**Application Reference:** 3/2026/0562

**Site:** Blackburn Rovers Academy Training Ground Brockhall Village Old Langho  
Blackburn BB6 8BA

**Proposal:** Proposed floodlighting and new covered seating.

**Sport England Reference:** PA/26/NW/RV/74665

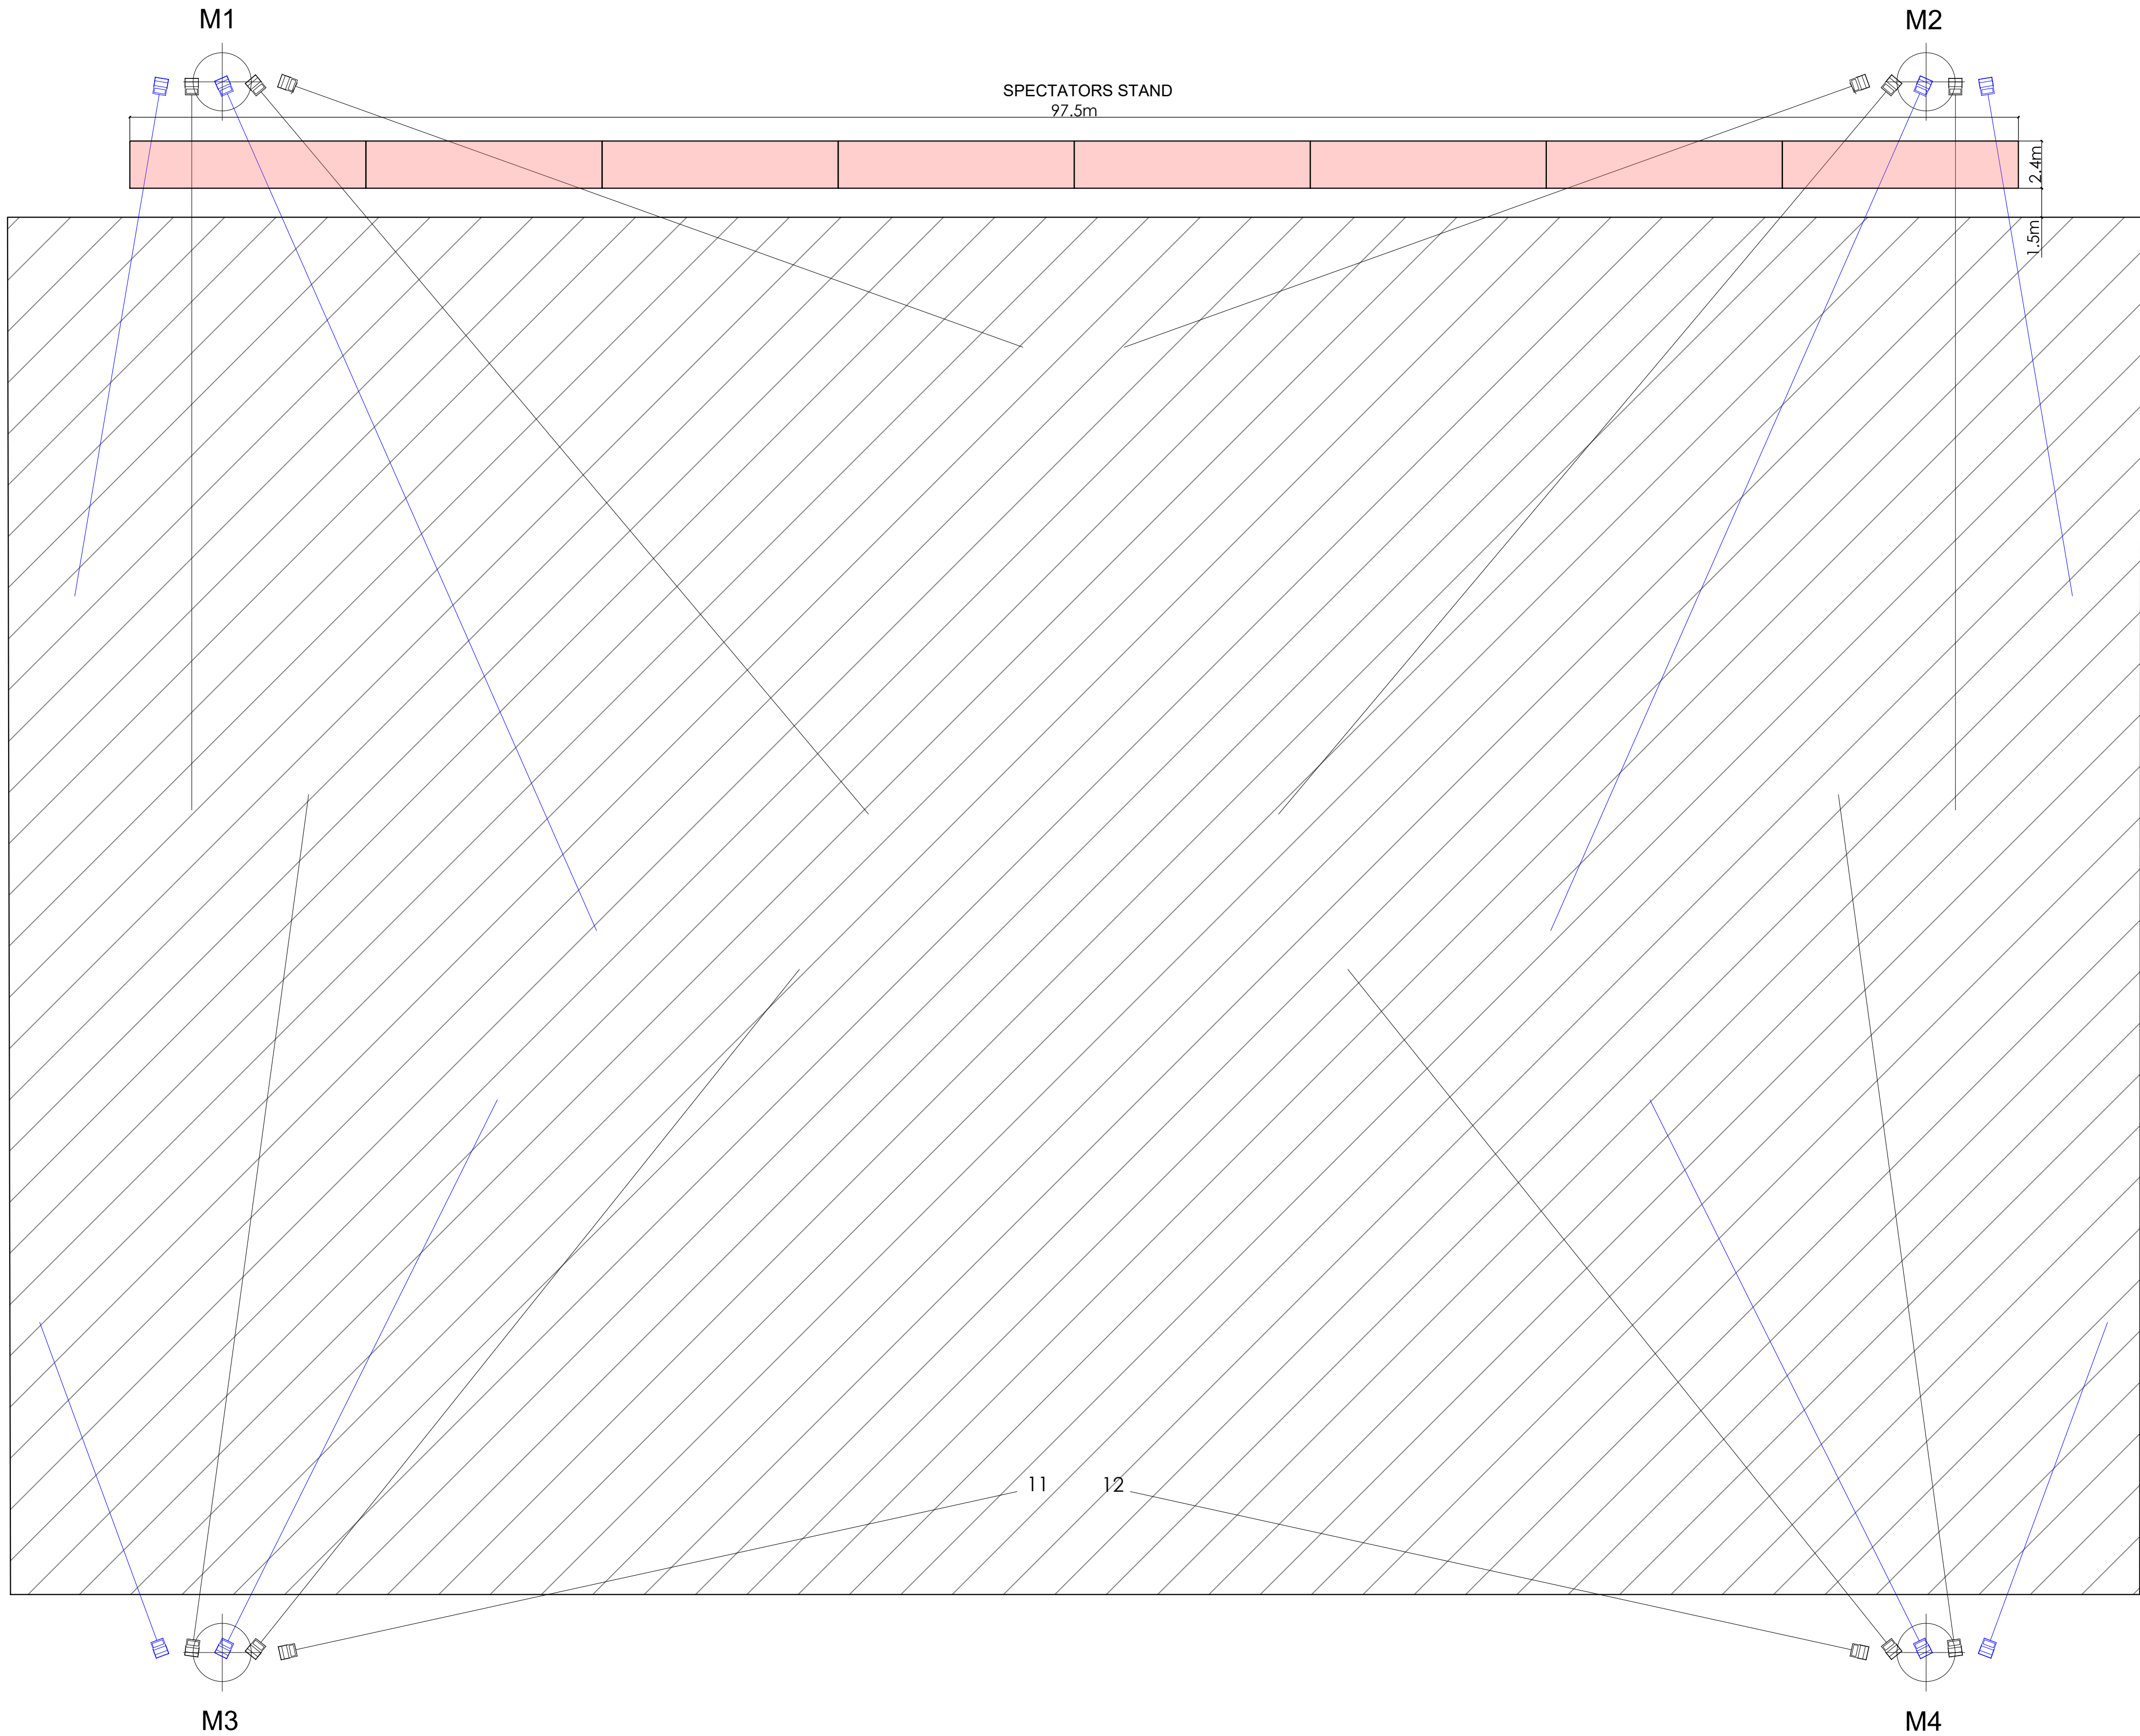
*The stand will remove the required 3m run-off from the youth pitch, and although this doesn't affect current community usage given the professional nature of the site FF encourage the applicant to either move the pitch (if possible) or review the marked pitch dimensions to ensure the site is safe for users*

Looking at the site via Google Earth, it is possible to relocate the pitch to achieve the necessary run-off areas.
